Subject: FW: PA/21/08 and PA/22/08/CA

From: Brian Banister
Sent: 14 October 2008 15:03
To: James Smith
Subject: PA/21/08 and PA/22/08/CA

PA/21/08

PA/22/08/CA

0616 SK18
Robinswood House
Proposed Elevations 1 of 2
July 2008
Scale 1:100

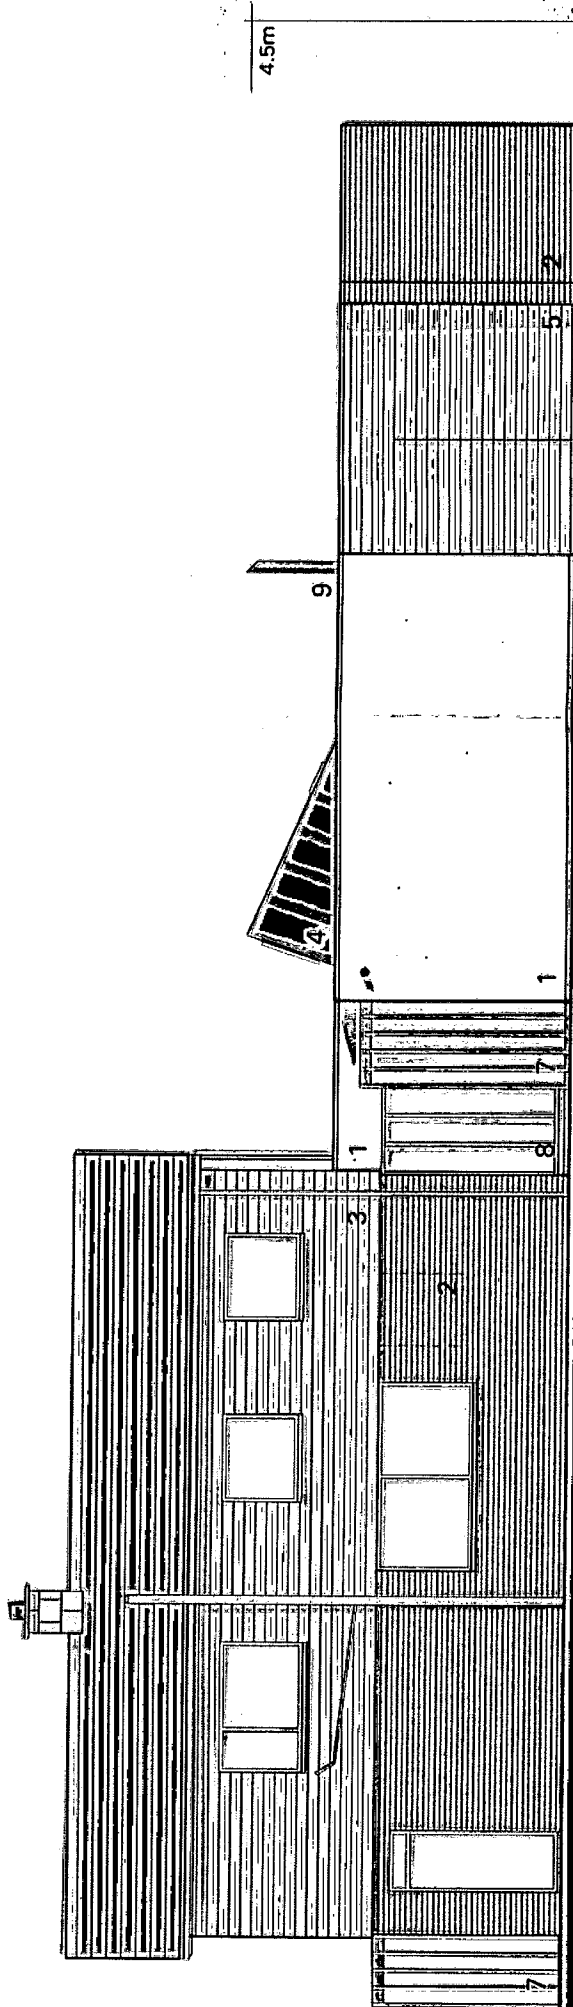
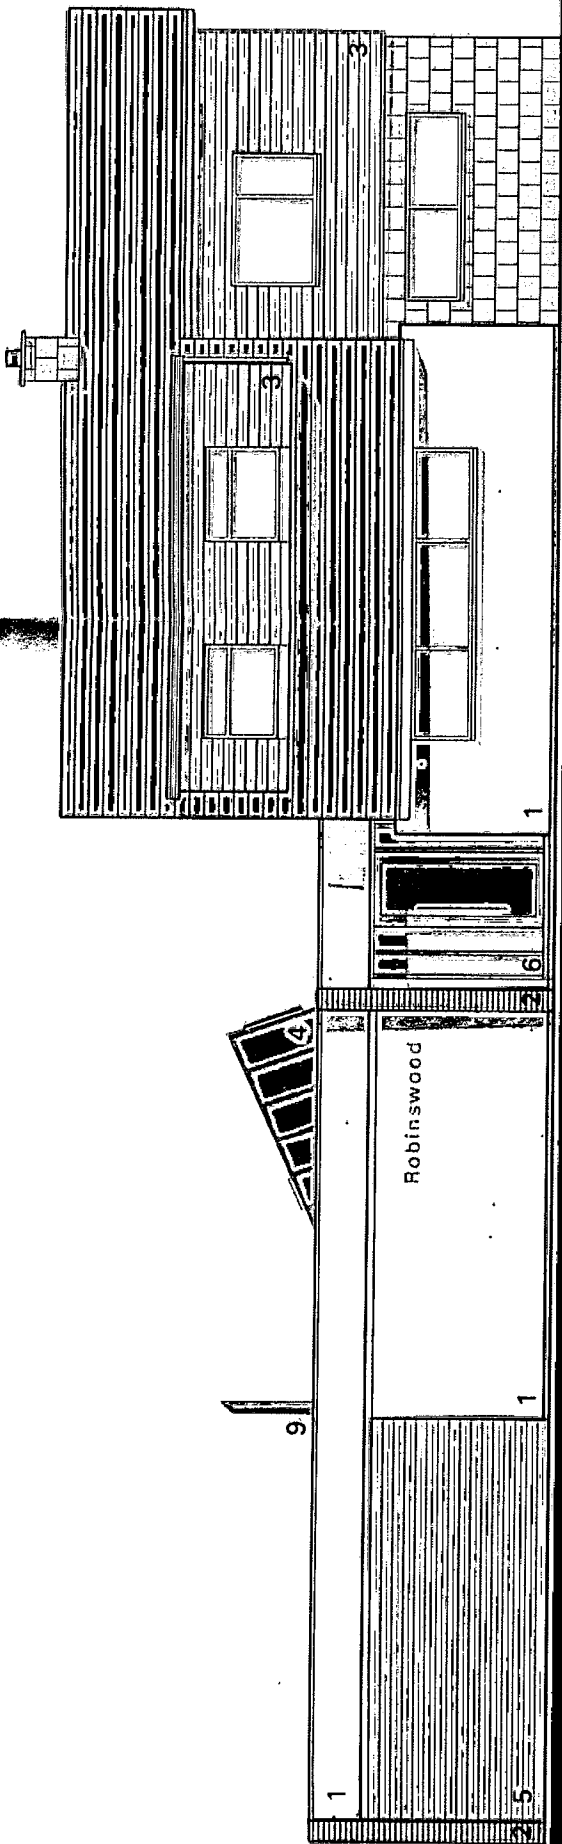
The proposed extension is on the large side but it is, in my opinion, well designed of contemporary style, which is appropriate given the design of the existing main building. It is also located at the rear of the property which lies in a heavily wooded setting so that I do not consider that the proposals will have an adverse effect on the character or appearance of the Conservation Area or the AONB.
